Your Ref: OWPC18262
Our Ref: AW/90/18/HH
Please ask for:
Mr R Leal

17th May 2018

Two storey rear extension & first floor extensions to front & side.
8 Merton Close Aldwick

192-01C

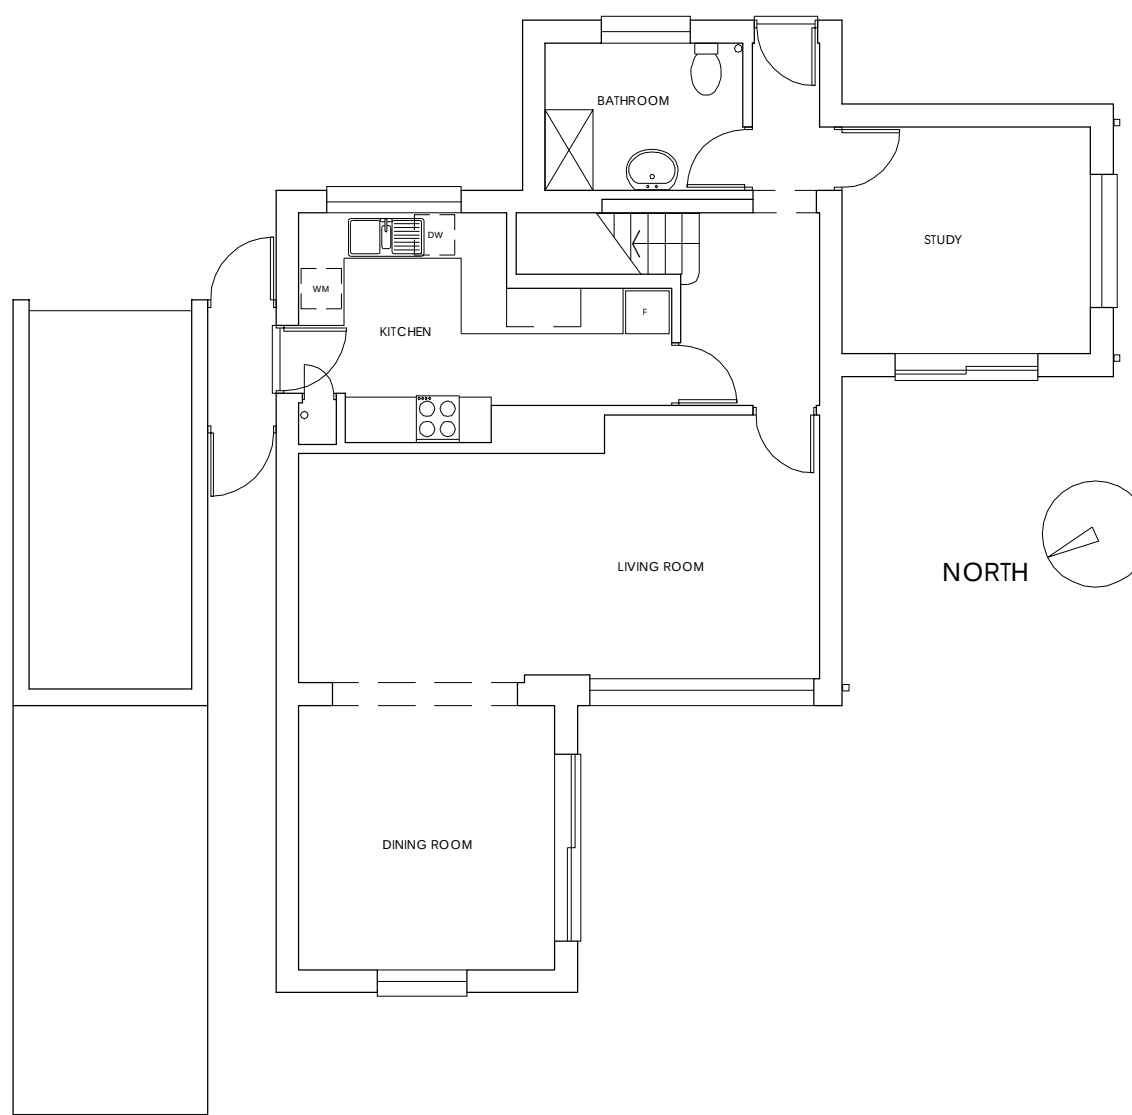
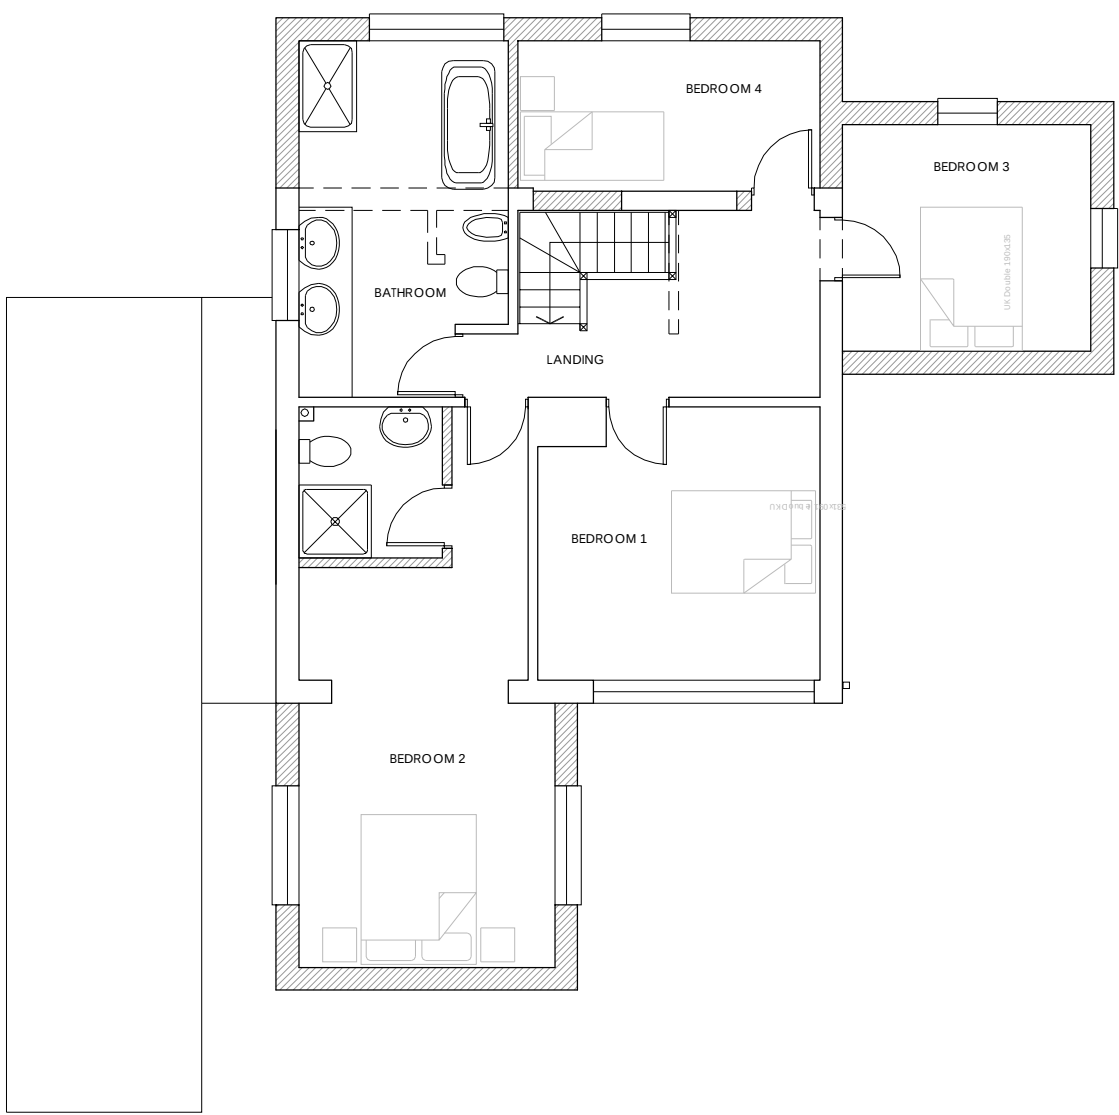
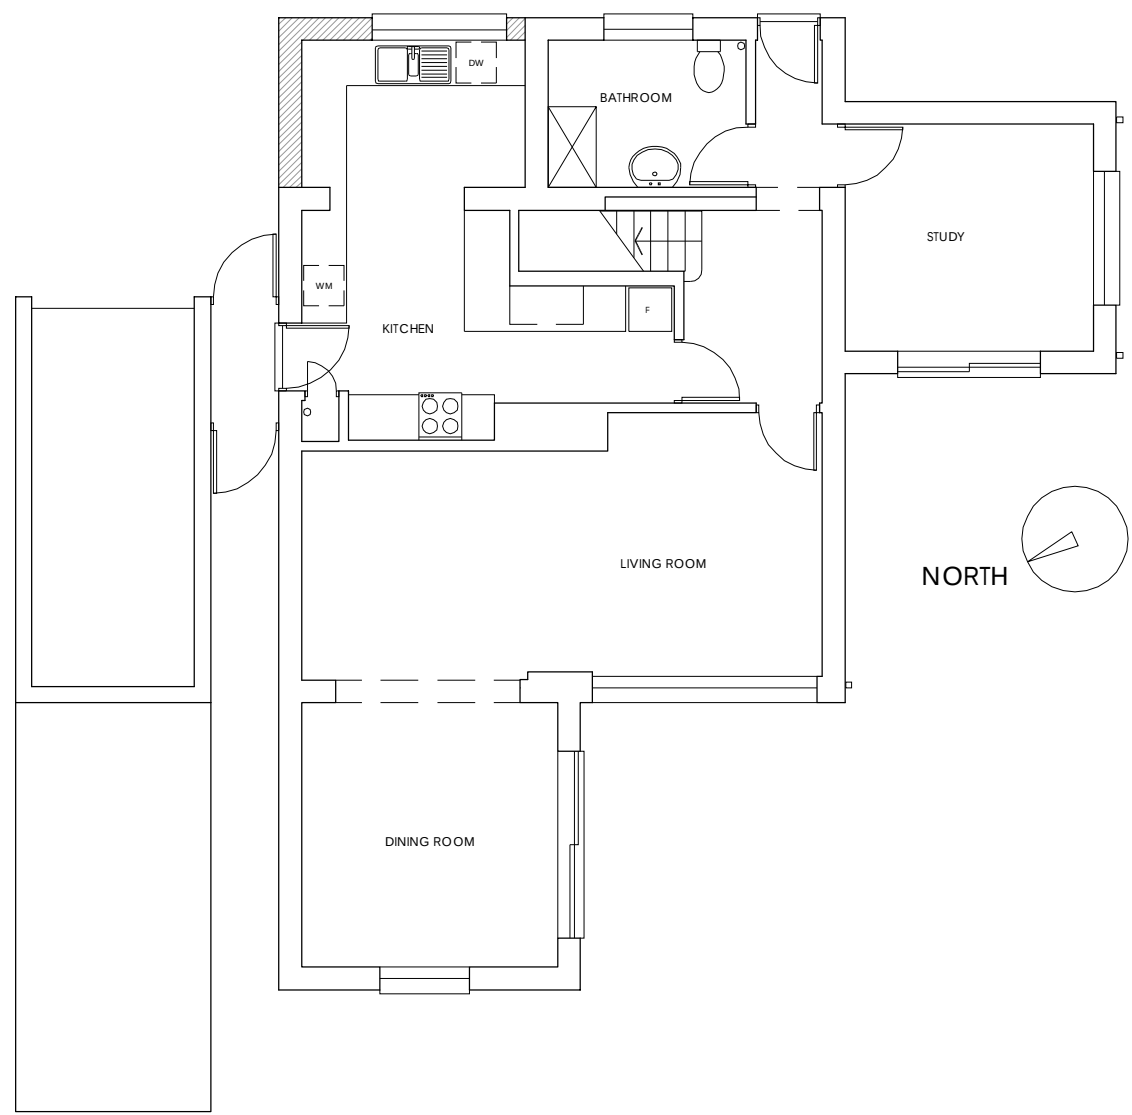
Members strongly opposed the application on the grounds that the proposed extension does not sympathetically relate to and is not visually integrated with the existing building in siting design form scale and materials - they specifically identified the cladding as being is considered out of character with existing materials- and because the extension is not visually subservient to the main building and because the extension would have an adverse overshadowing, overlooking or overbearing effect on neighbouring properties and because the extension compromises the established spatial character and pattern of the street. Therefore Members agreed that the application is in direct conflict with Policy Dev 19 (i); (ii); (iii) and (v) of the Arun District Local Plan 2003 and with the Parish Design Statement page 71).
